Chapter Eighteen ◆ Soils, Hydrogeology and Ground Conditions

- 18.1 This chapter provides an assessment of the geoenvironmental information and likely significant effects of the Proposed Development in terms of soils, hydrogeology and ground condition impacts with respect to the Project Site. This chapter was originally published in December 2020 but has since been updated (July 2021) to reflect; the notification of the Swanscombe Peninsula as a SSSI, changes to the proposed development, additional work undertaken with respect to ground conditions and further information received. Consideration has been given to the Project Site conceptual models including geology, hydrology, hydrogeology and the geoenvironmental conditions (including issues associated with soil gases, chemicals within soils and groundwater). A range of impacts associated with the design, construction and operation of the Proposed Development have been assessed.

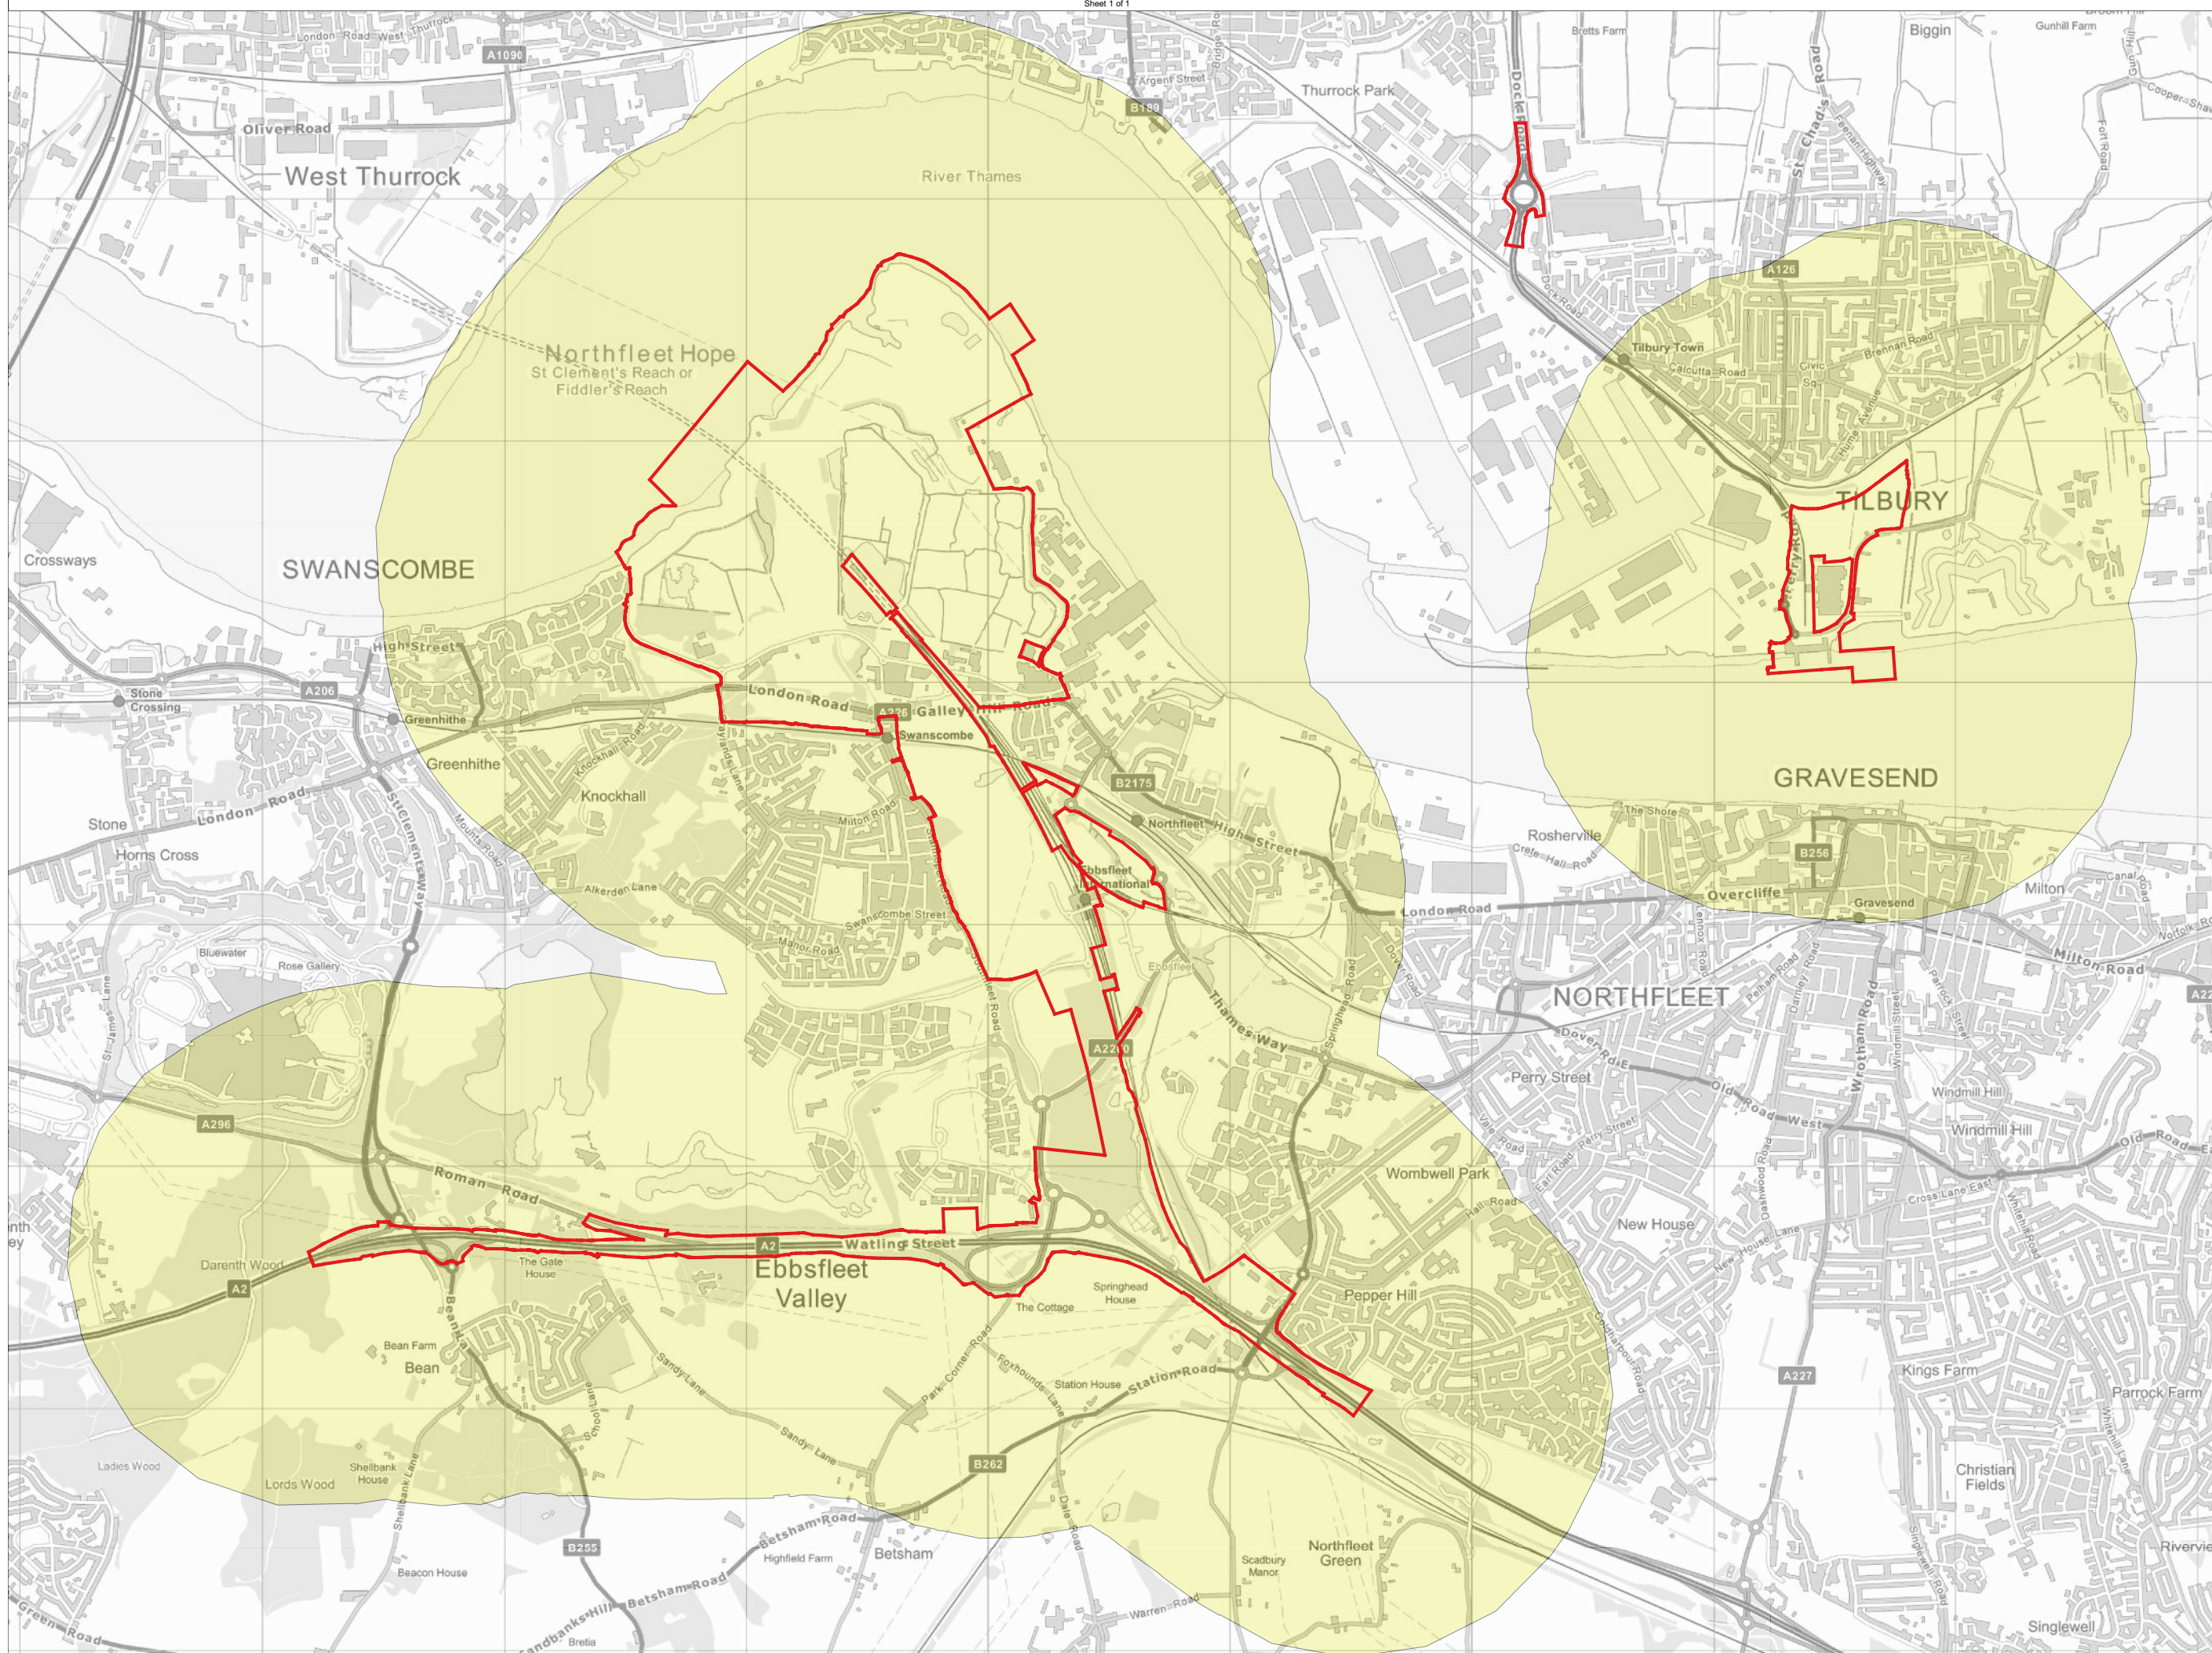
Ebbsfleet DC	With regards to the study area for contamination / ground conditions, it was stated <i>'These areas should be clearly described within the ES and illustrated on a figure/plan.'</i>	The study area (DCO Order Limits with 1km buffer) is illustrated by Figure 18.1.
